Town & Country Planning Act 1990 (as amended)
Town and Country Planning (Development Management Procedure) (England) Order 2015
Approval of details reserved by conditions imposed on planning reference AB/81/16/PL relating to
conditions 4 (materials), 5 (method statement) & 6 (bat/owl habitat)
Arundel Equine Centre Tortington Lane, Arundel,

Arun District Council have decided to **REFUSE details reserved by condition for the following reasons:**

PLOT 5 – Floor Plan

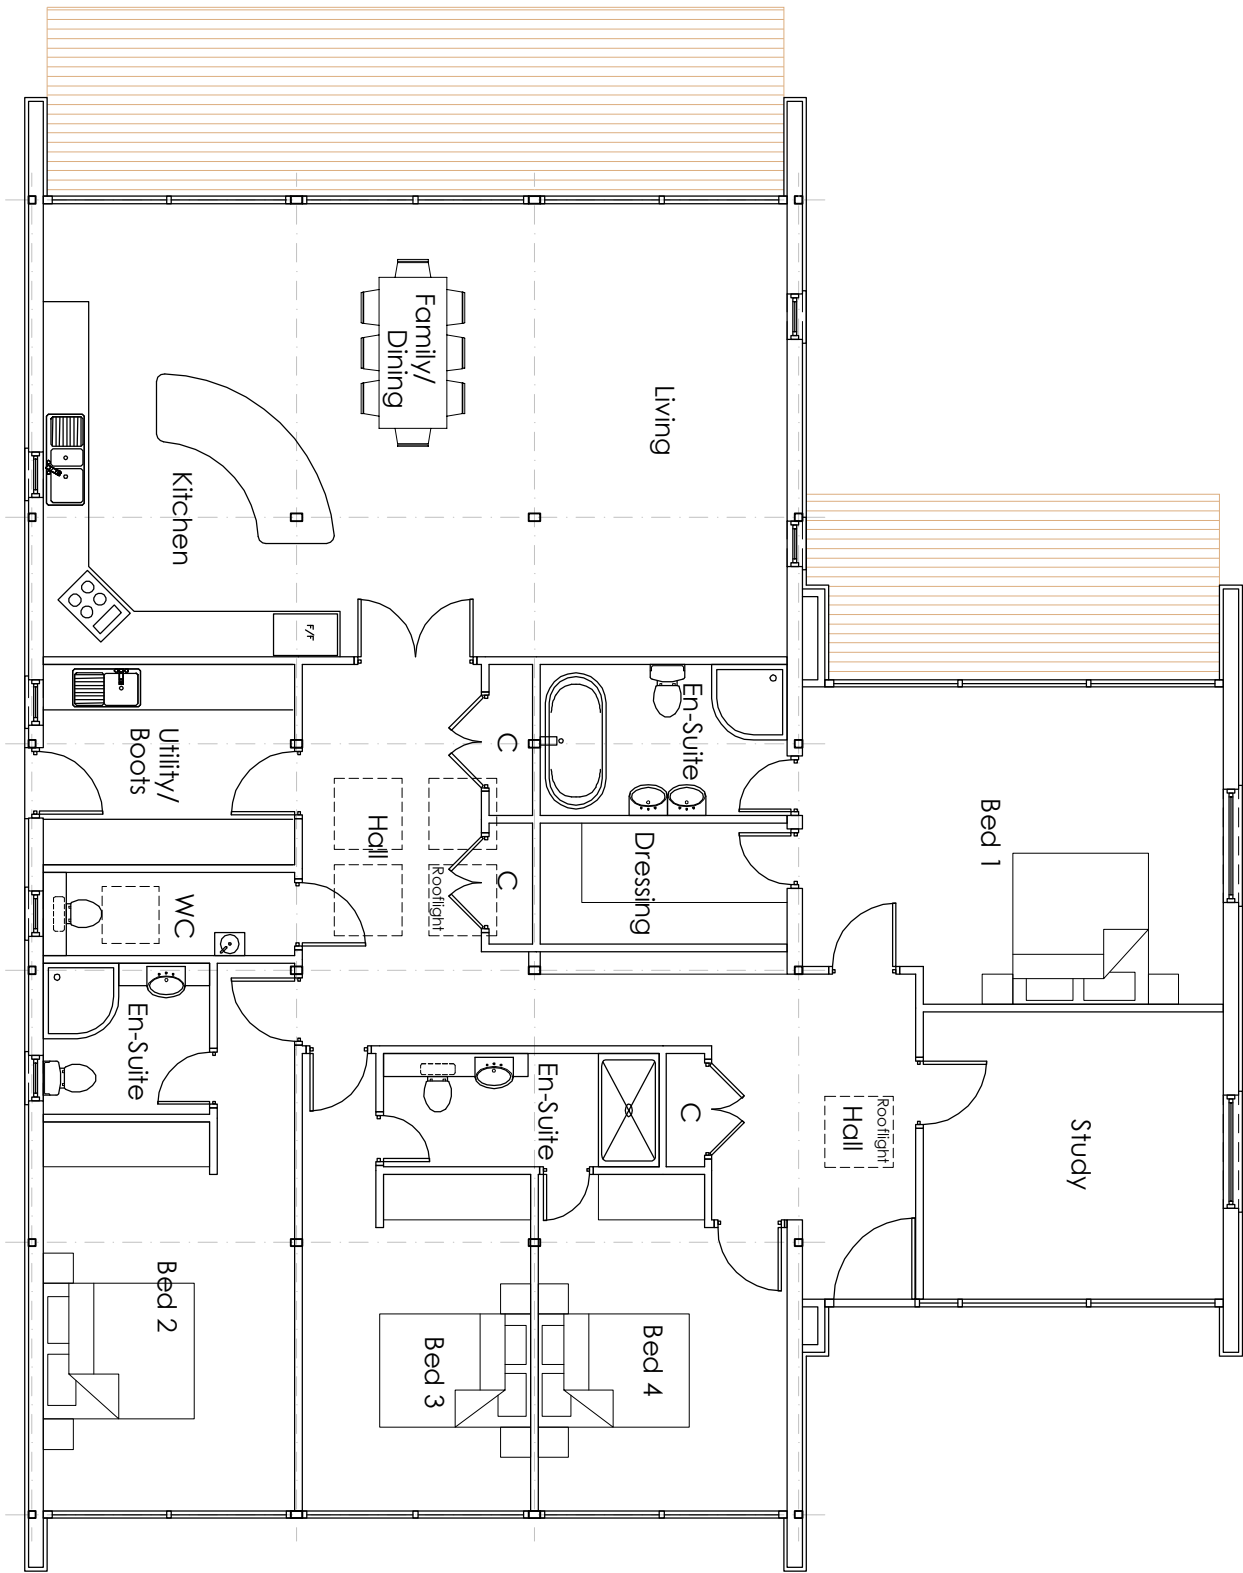
This condition is refused on the basis that the proposed plans are different from those approved. The change in design, window openings and size shown by the plans submitted under this discharge of condition application would need to be the subject of a revised application for planning permission.
